Planning Application Ref: M/80/19/PL

Location: Former Poultry Farm, Land West of Yapton Road, Middleton on Sea, PO22 6DY

Description of works: Demolition of the existing structures & redevelopment to provide a new 66-bedroom care home (Use Class C2) arranged over two storeys together with associated access, car and cycle parking, structural landscaping and amenity space provision

Comments on Application:

Key:

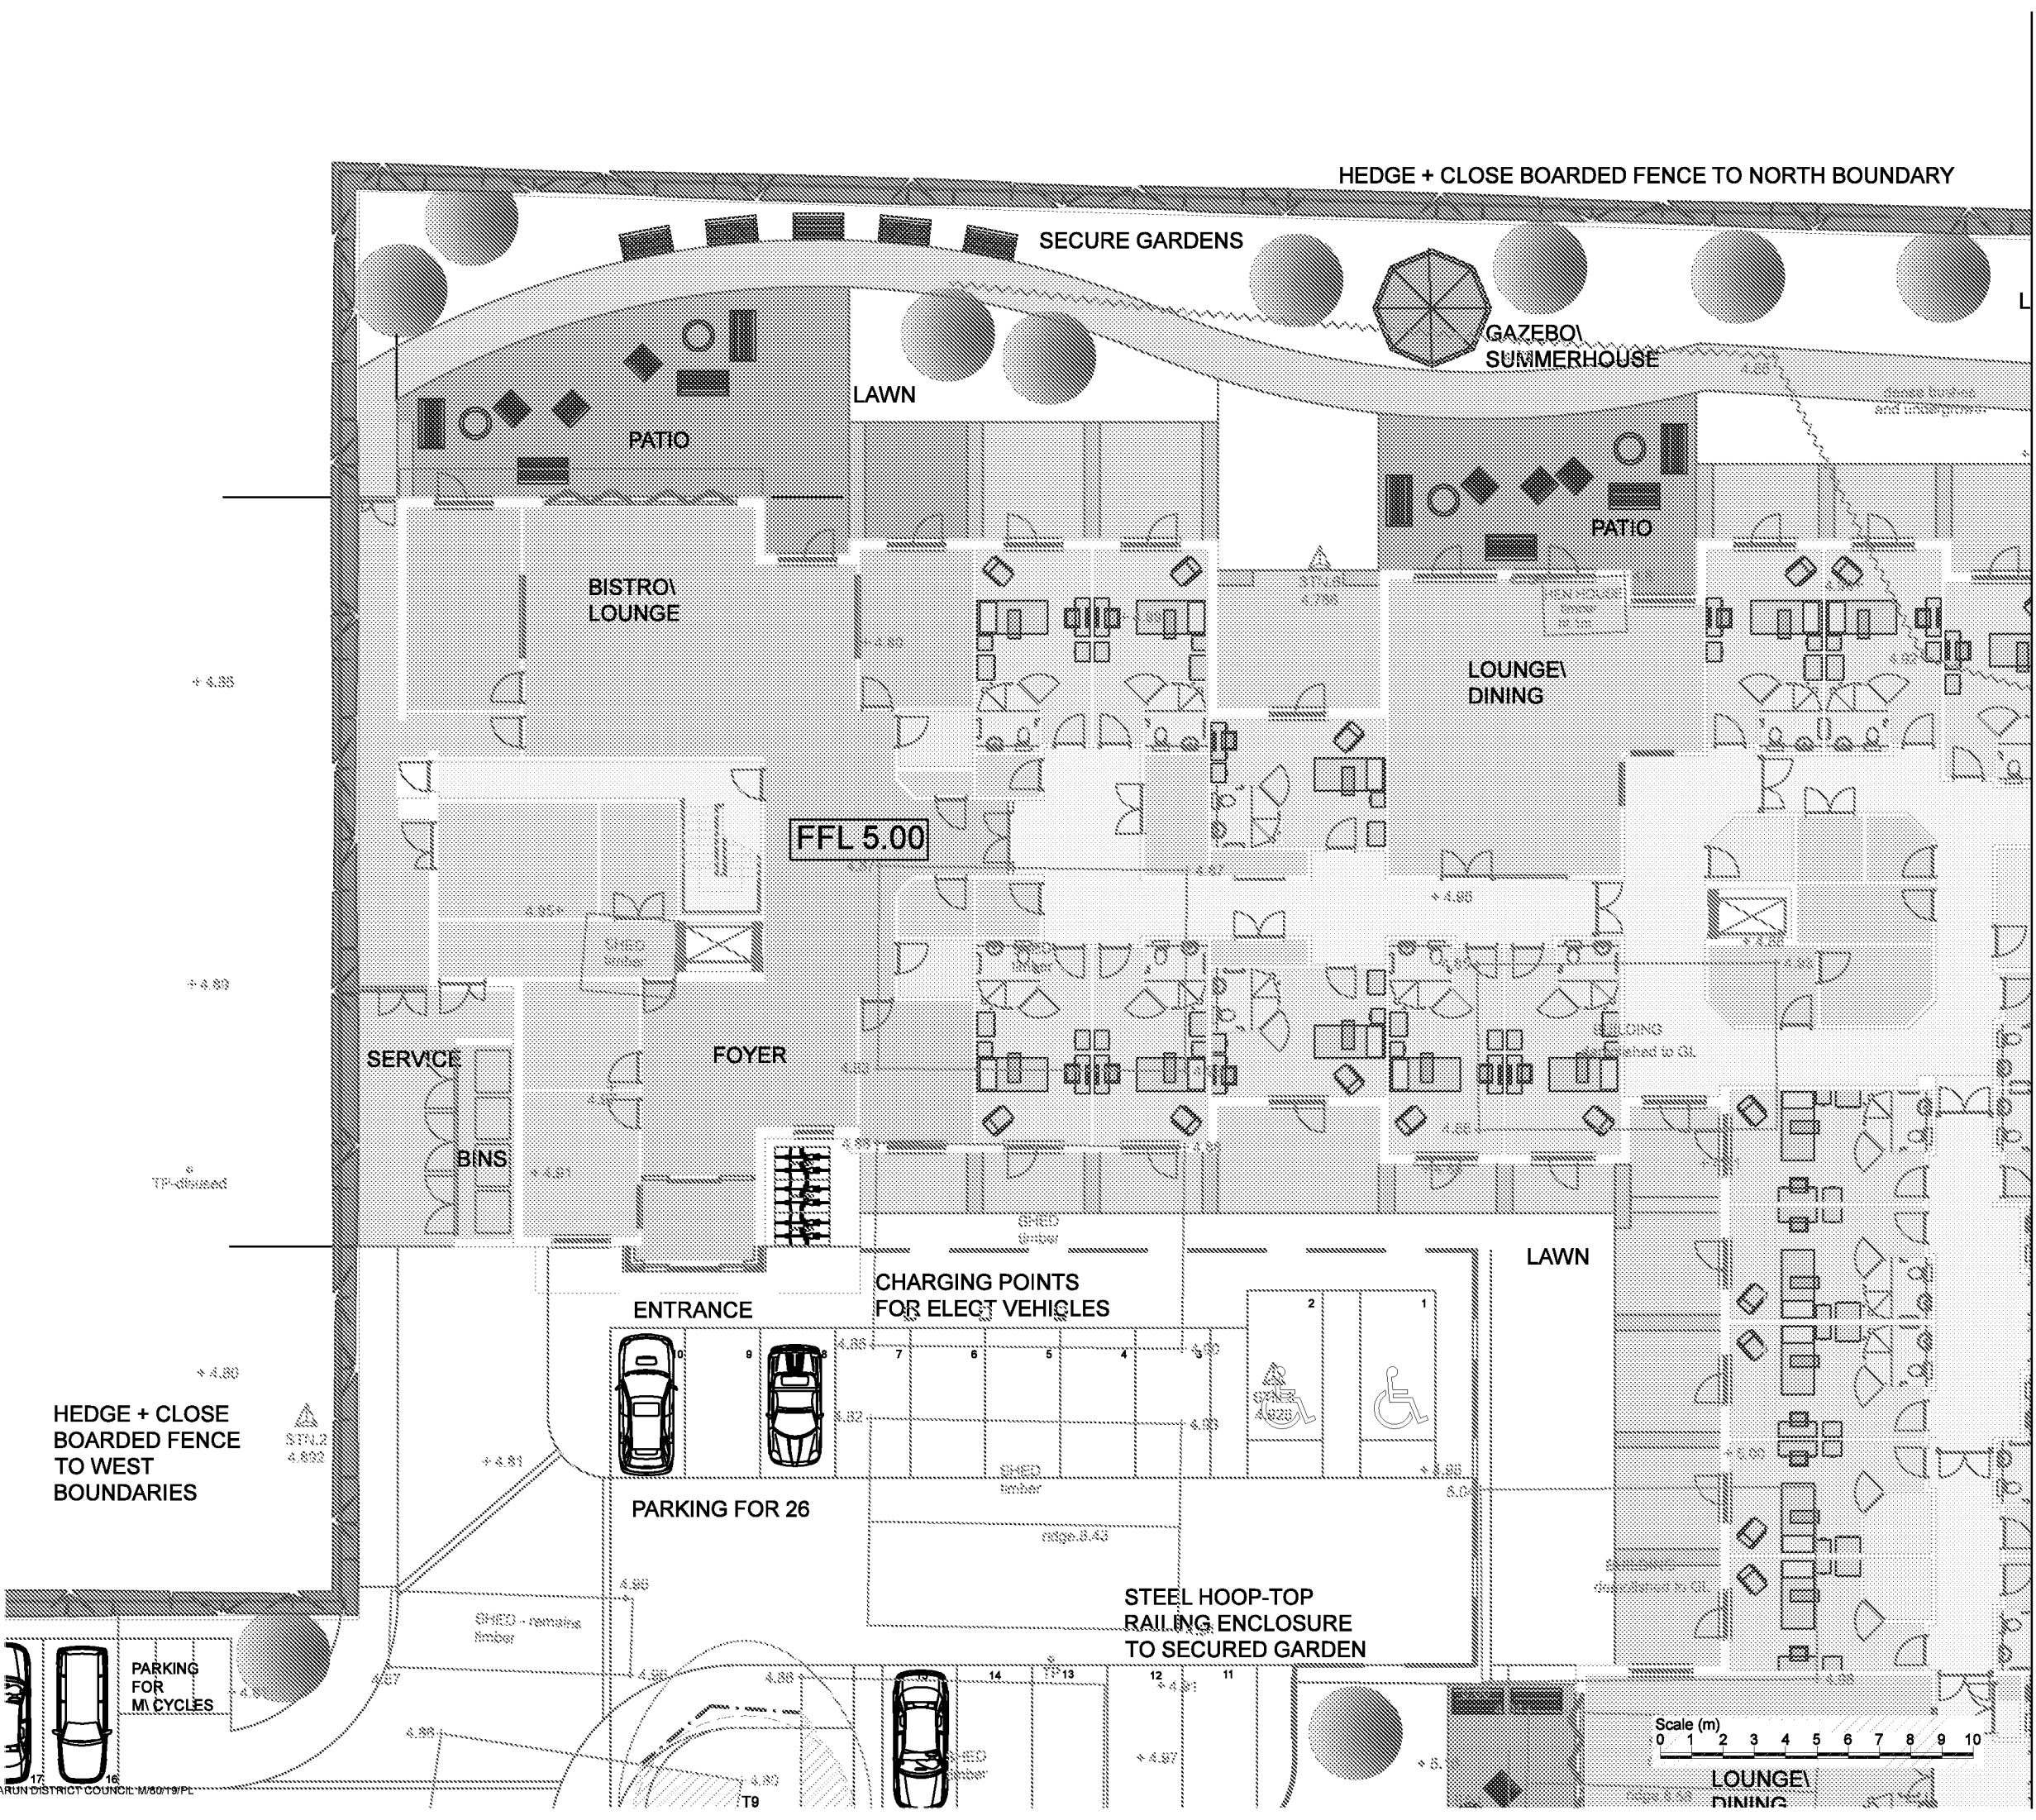
- If you are of a mind to approve this scheme as it stands, then I would recommend the following conditions be applied:
 1. Before the site is occupied or any machinery is introduced to the site or demolition work or construction work or alterations to existing ground levels takes place a **PRE-COMMENCEMENT Site Meeting** is to take place between the Planning Authority's Tree Officer and the Arboricultural Expert representing the site owner(s) – at this meeting all protective fencing and ground protection measures will be inspected to verify they are 'Fit for Purpose' as required under British Standard 5837:2012 and have been erected and positioned exactly as shown on the **Tree Protection Plan, PJC/5256/19/C (sheets 1 to 4), 28/08/2019.**
